Re: Planning Application 19/0985

Address: 29 Glendale Drive Mellor Blackburn BB2 7HB

Description: Extension to existing garage to include bedroom and new double garage.

Client: Mr K and Mrs J dean
 Title: Proposed Detached Double Garage
 Drawing: Scheme Proposals

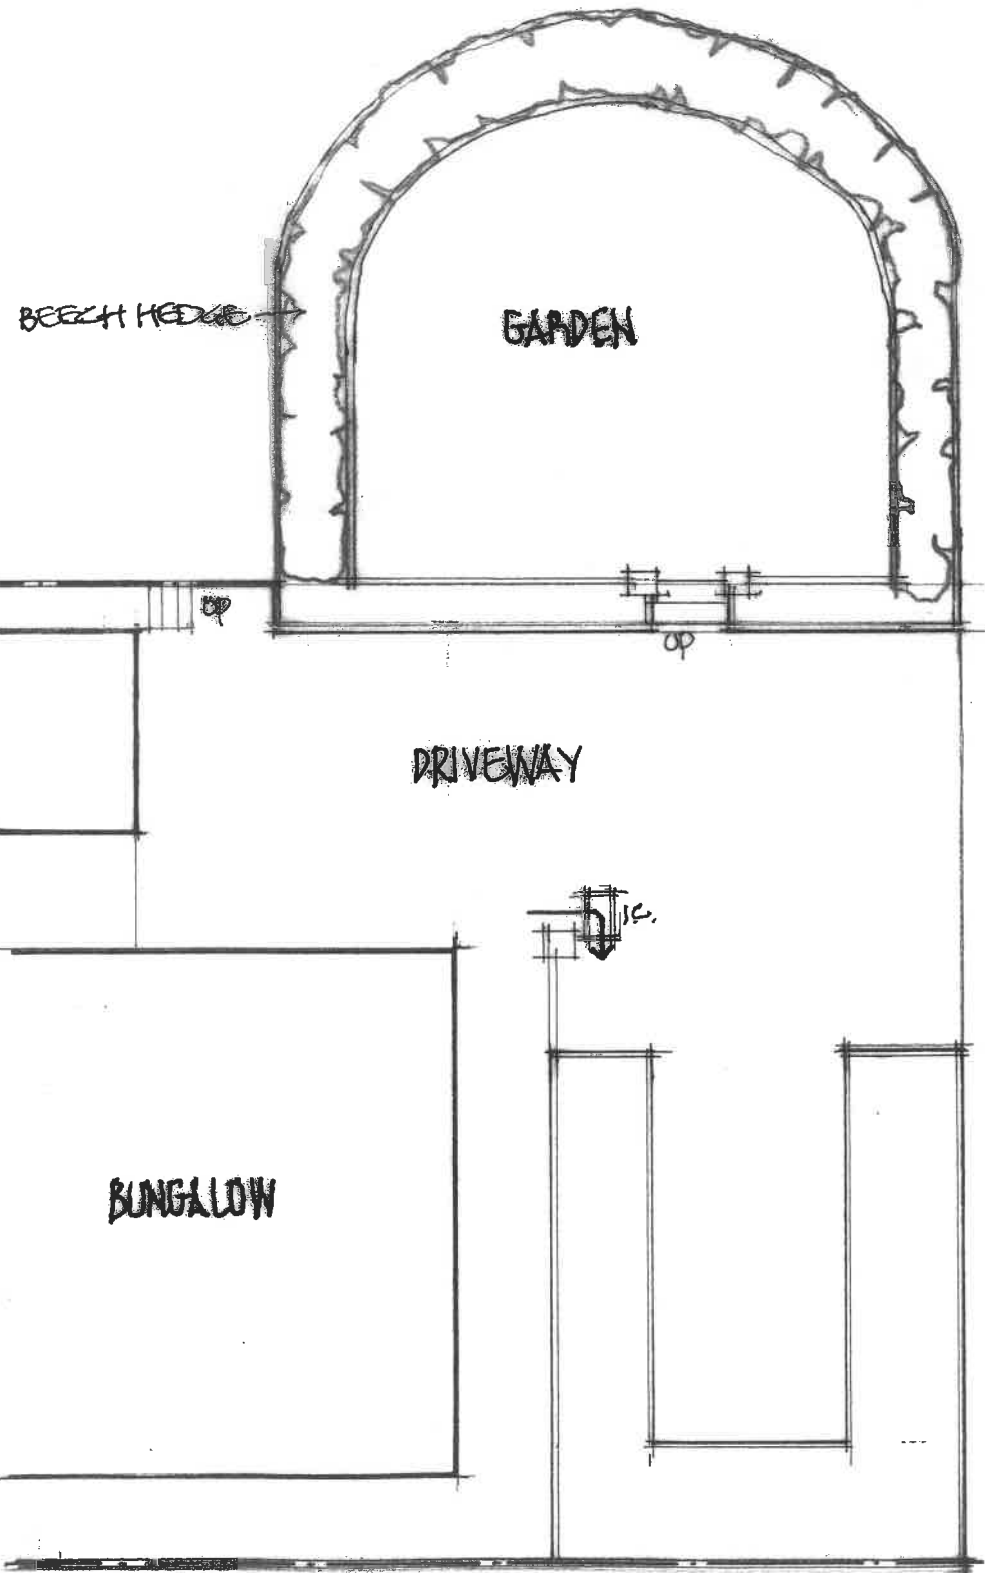
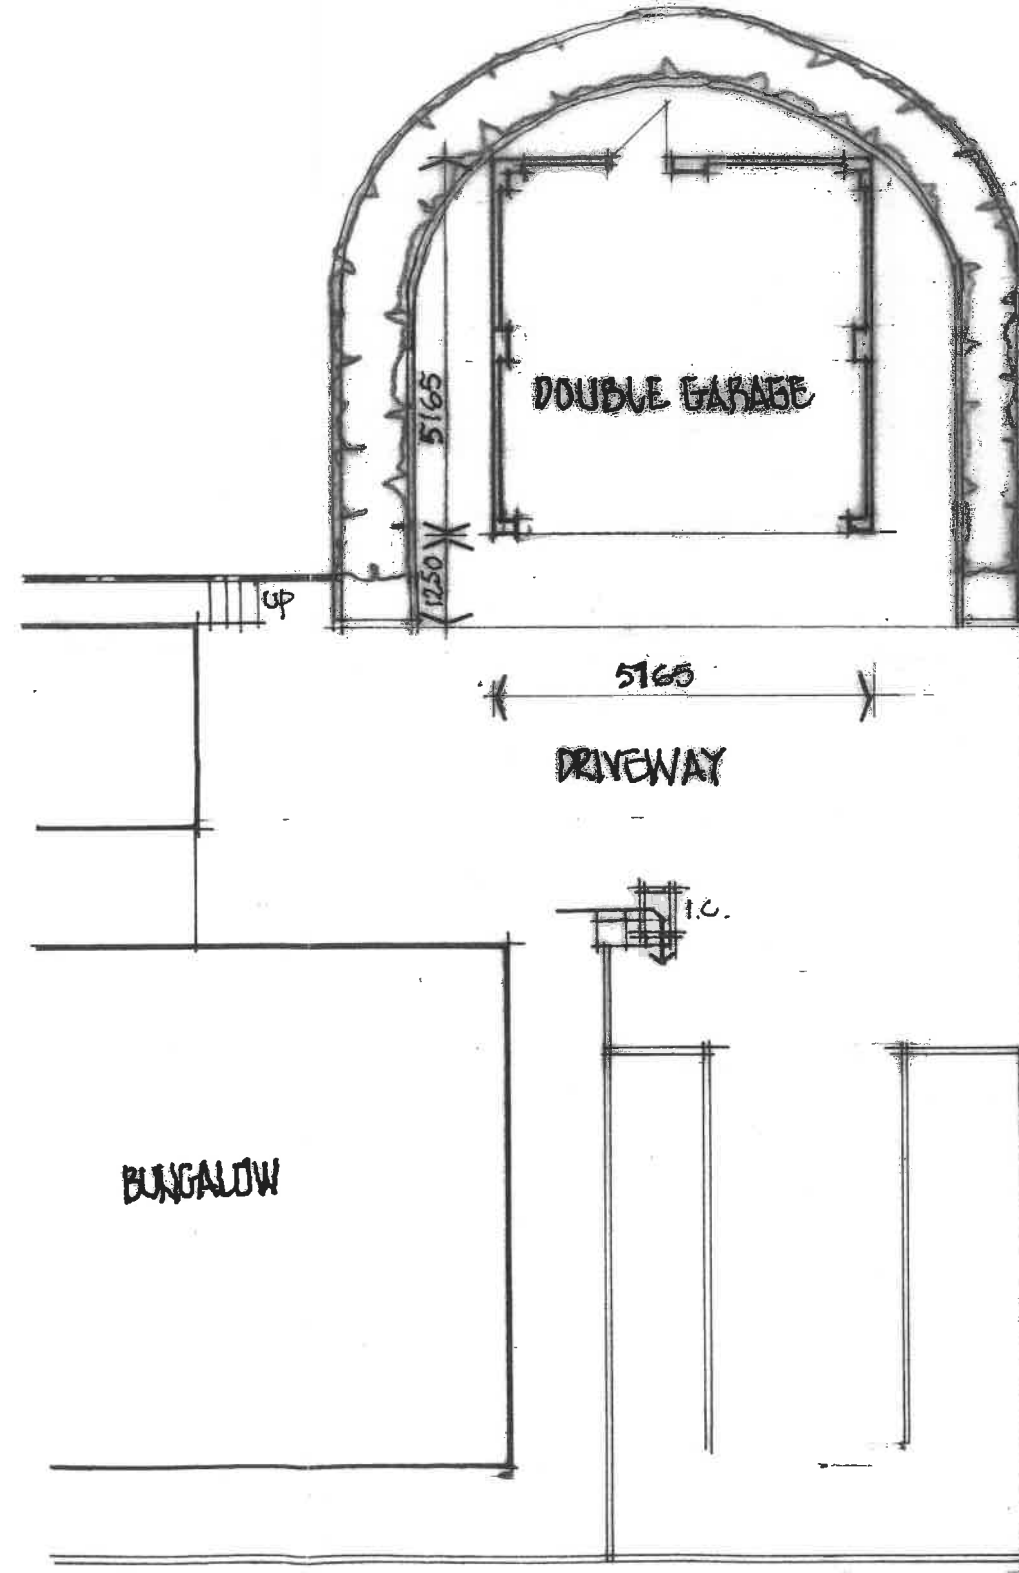
The dwelling is to become a 4 bedroomed house, which according the Lancashire's Parking Standards should have 3 off street parking spaces.

Whilst a garage is being provided it is not considered to be of a suitable size, guidance from the Department of Transport's document Manual for Streets would indicate that a single garage should be 3m x 6m. Any off street parking spaces should be at least 2.4m wide and 5.5m long, an additional width of 0.6m should be provided where a space is adjacent to a wall to allow space for the car door to open. Where the driveway is used as the pedestrian access an additional width of 0.8m should be provided.

Client: Mr K and Mrs J dean
Title: Proposed Extension to form bedroom and
 Detached Double Garage
Drawing: Site Block Plans

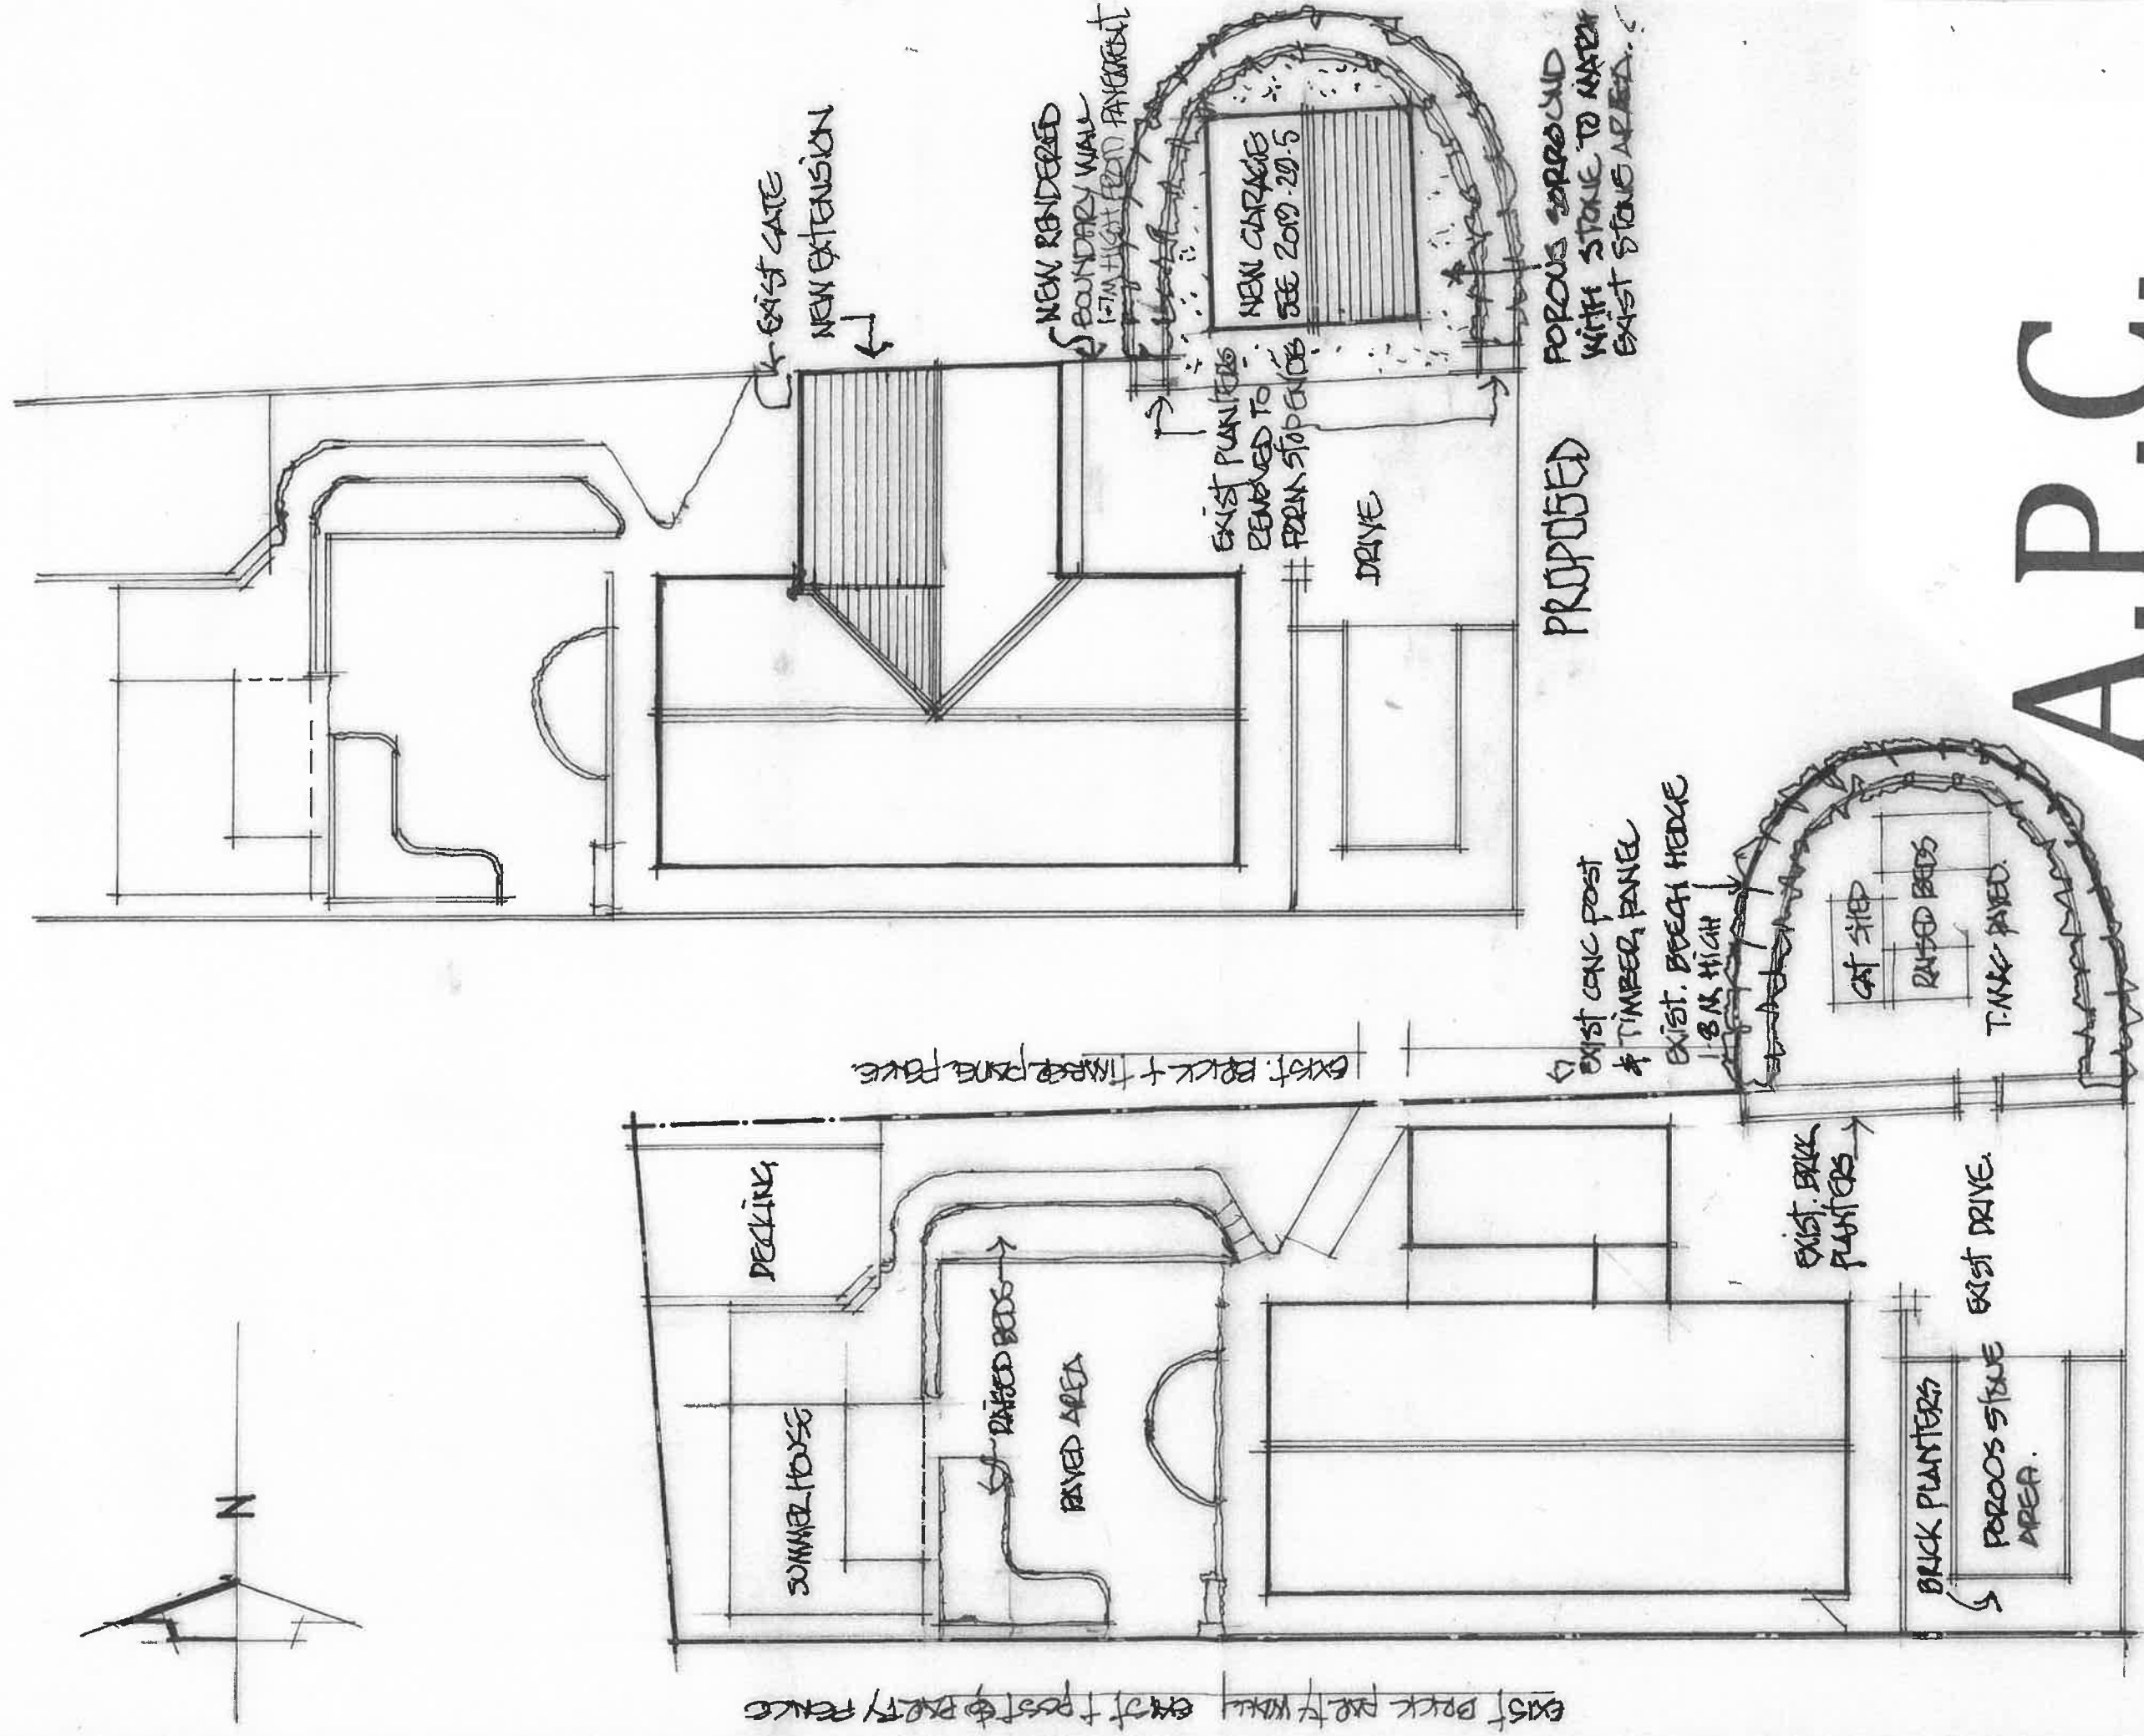
In order to support this application we would look for further plans showing how the parking requirements can be accommodated. It may be necessary to widen the driveway access by way of lowering additional kerbs.
